From: Ward, Stuart [REDACTED]
Sent: 16 January 2018 11:45
To: Paul Cann; Planning.Responses
Cc: Jenkins, Samantha
Subject: RE: Planning Consultation on EG/107/17/DOC

APPLICATION **EG/107/17/DOC**
NO:

Registered: 21-DEC-17
Site Address: 97 Barnham Road Eastergate PO22 0EQ

Description of Works: Application for approval of details reserved by condition imposed under planning application EG/38/15/PL relating to condition No. 3 - Surface water drainage

Number
S17-03-01 E

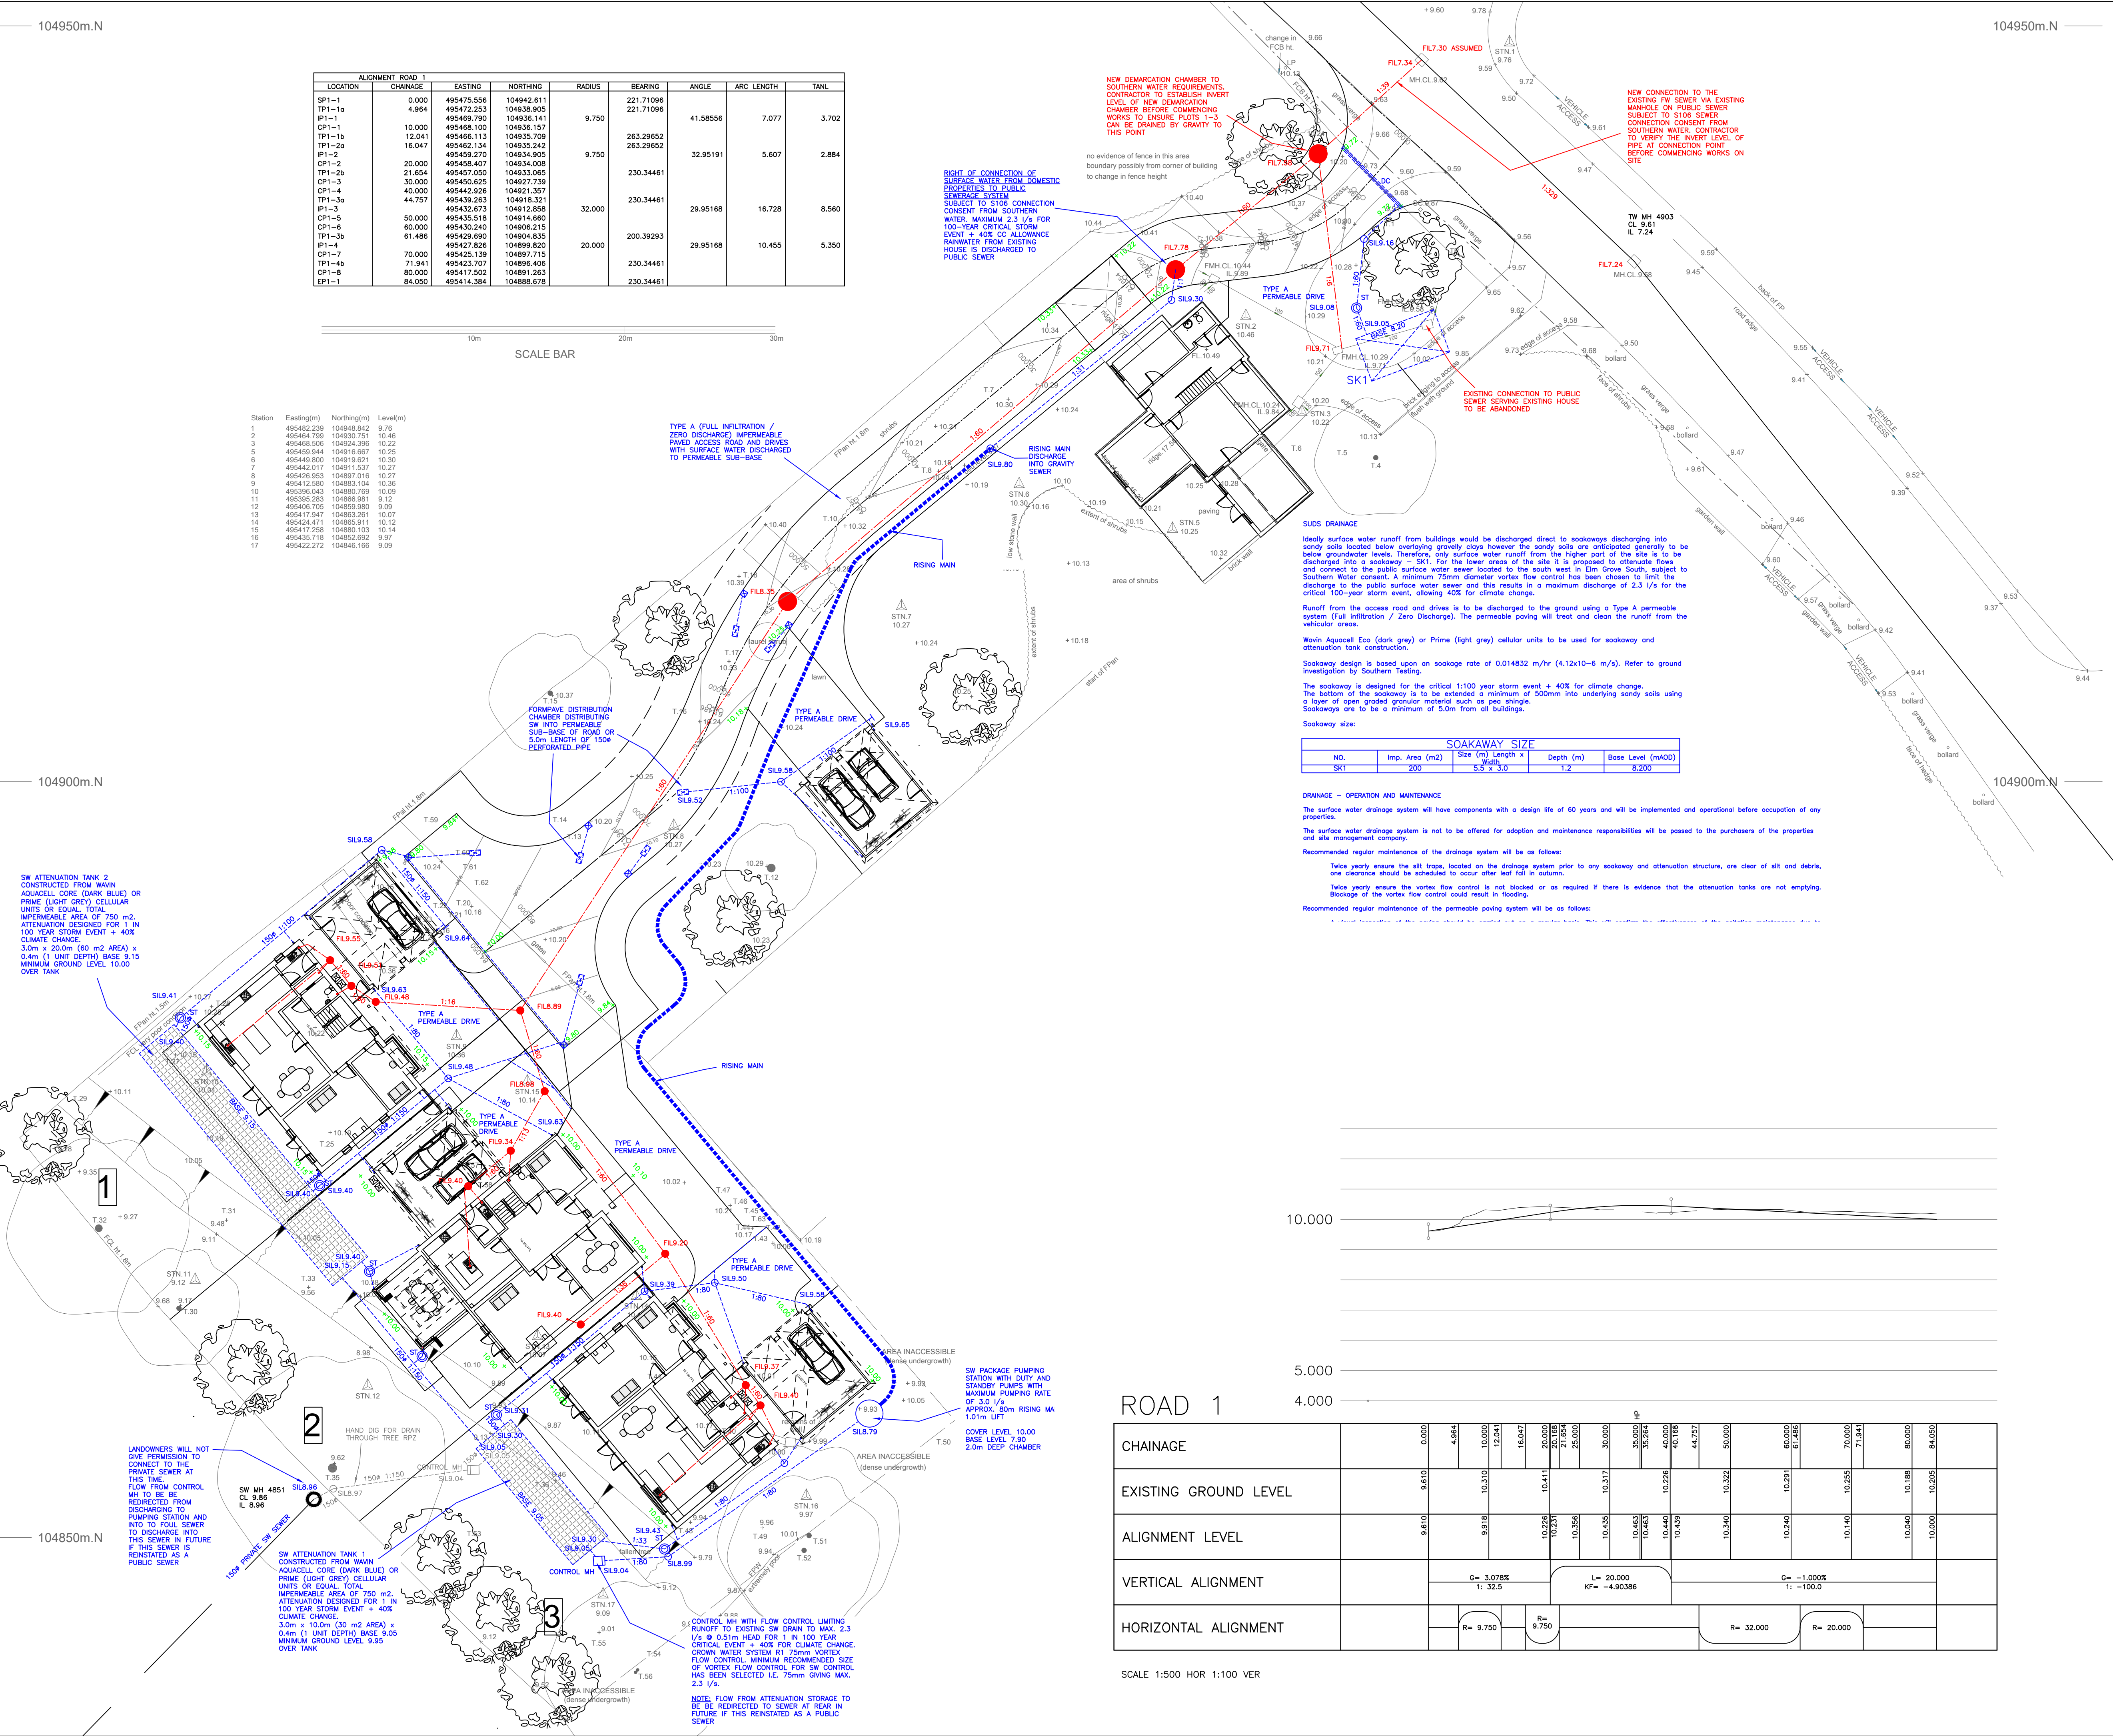
I would agree that the flow rate should not exceed the agreed flow rate of 2.3 l/s. They will need to amend the rate to the agreed flow rate (2.3 l/s) as any additional flows could lead to flooding downstream of the development site.

1. Provide full construction details of the package pumping station, including alarm arrangements in case of malfunction.
2. Specify rising main details (diameter/material/bedding) including thrust blocks.
3. The pump rate (note by pumping station) stipulates a max. flow rate of 3 l/s which is greater than the flow rate of 2.3 l/s required by Southern Water. Please provide confirmation from Southern Water that this is acceptable.
4. The final pipe before discharge to the foul manhole in the access road is proposed at a gradient of 1 in 1 which is too steep and will have a negative effect on foul flows within the sewer. Specify an external backdrop with soffit to soffit connection (with Southern Waters agreement).
5. The pumping station, etc will need to be maintained by the management company/residents.
